**PERMIT NUMBER**  
**SFD2405-0021**

Description: <b>40x34 sfd 3 beds 2 baths</b>			
Type: <b>SINGLE FAMILY DWELLING</b>	Subtype: <b>SFD MONO</b>	Status: <b>ISSUED</b>	Applied: <b>5/8/2024 KBG</b>
Parcel No: <b>0566-39-8395.000</b>	Site Address: <b>4694 MCNEILL HOBBS RD BUNNLEVEL, NC 28323</b>		Approved: <b>12/11/2024 BS</b>
Subdivision: <b>DS-04277-001-001MCNEILL HOBBS FARM</b>	Block:	Lot: <b>00003</b>	Issued: <b>12/19/2024 MM</b>
Lot Sq Ft: <b>0</b>	Building Sq Ft: <b>0</b>	Zoning:	Finalized:
Valuation: <b>\$0.00</b>	Occupancy Type:	Construction Type:	Expired:
No. Buildings: <b>0</b>	No. Stories: <b>0</b>	No. Unites: <b>0</b>	
Details:

Truss Placement Plan
 SCALE: NTS

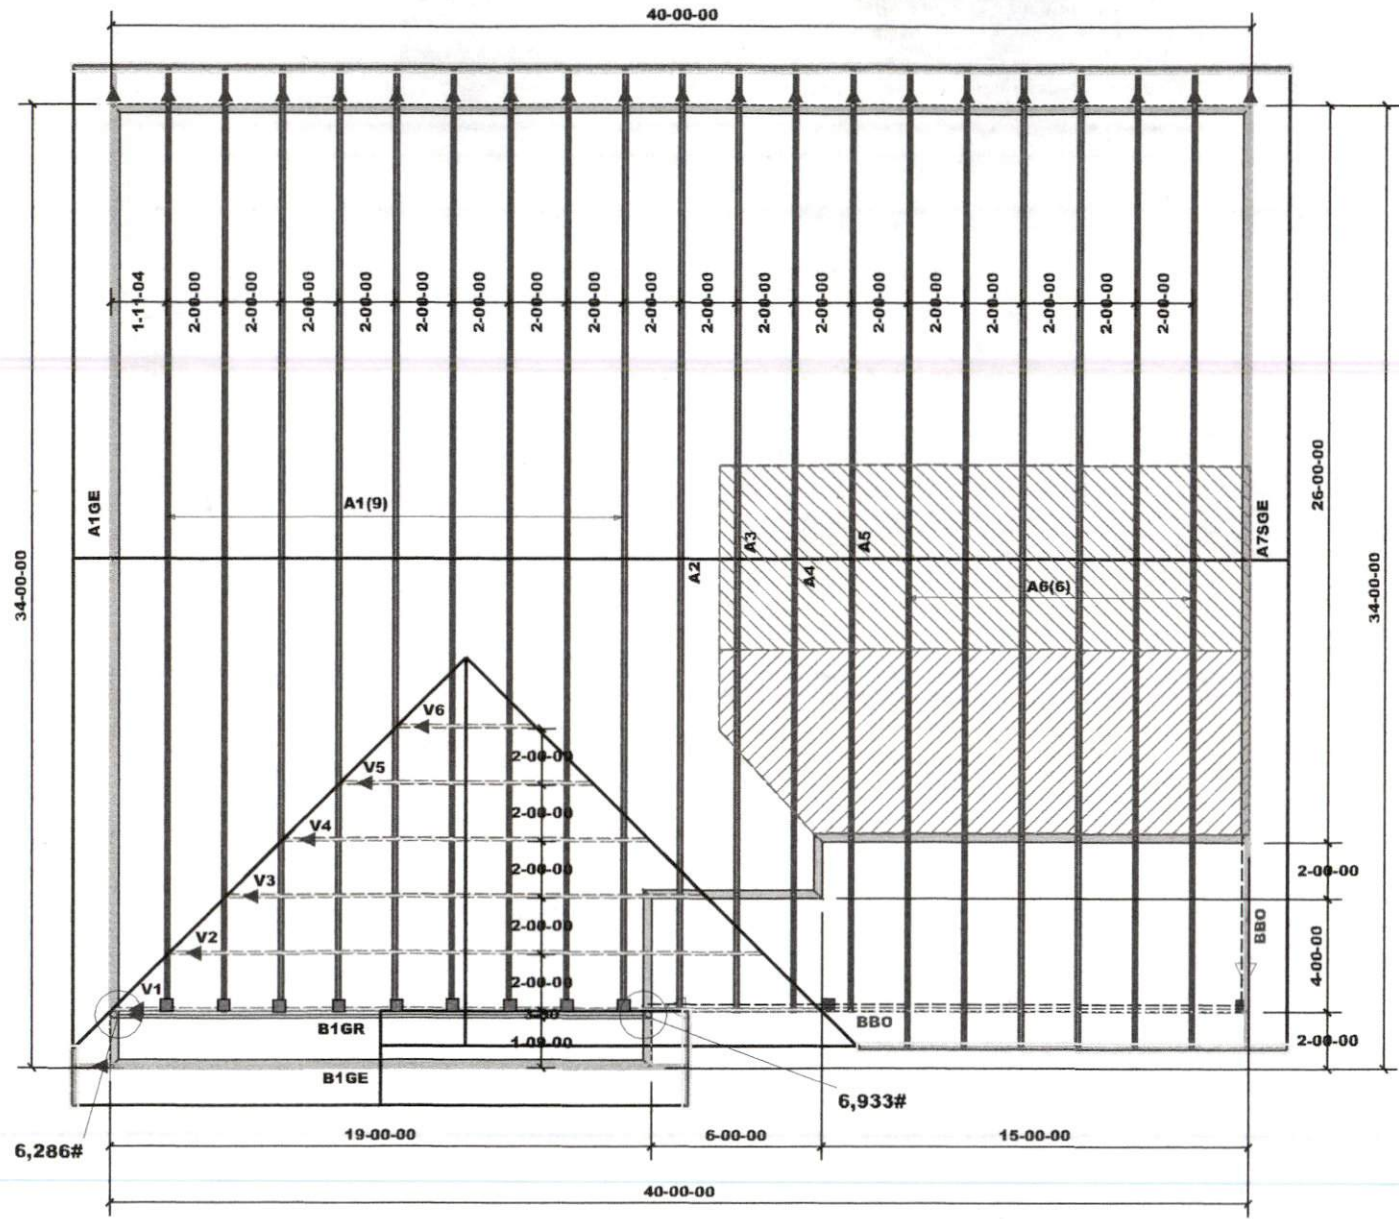
REVIEW TYPE	REVIEWER	SENT DATE	DUE DATE	RETURNED DATE	STATUS	REMARKS	NOTES
SFD INTAKE	CP Bucket	5/8/2024		7/1/2024	APPROVED		
RESIDENTIAL BUILDING	Brad Sutton	5/8/2024	5/13/2024	5/13/2024	DISAPPROVED	B6	Need truss layout from supplier
ENVIRONMENTAL	MARK OSBORNE	6/14/2024	6/21/2024	6/18/2024	APPROVED		
RESIDENTIAL BUILDING	Brad Sutton	12/6/2024	12/11/2024	12/11/2024	APPROVED
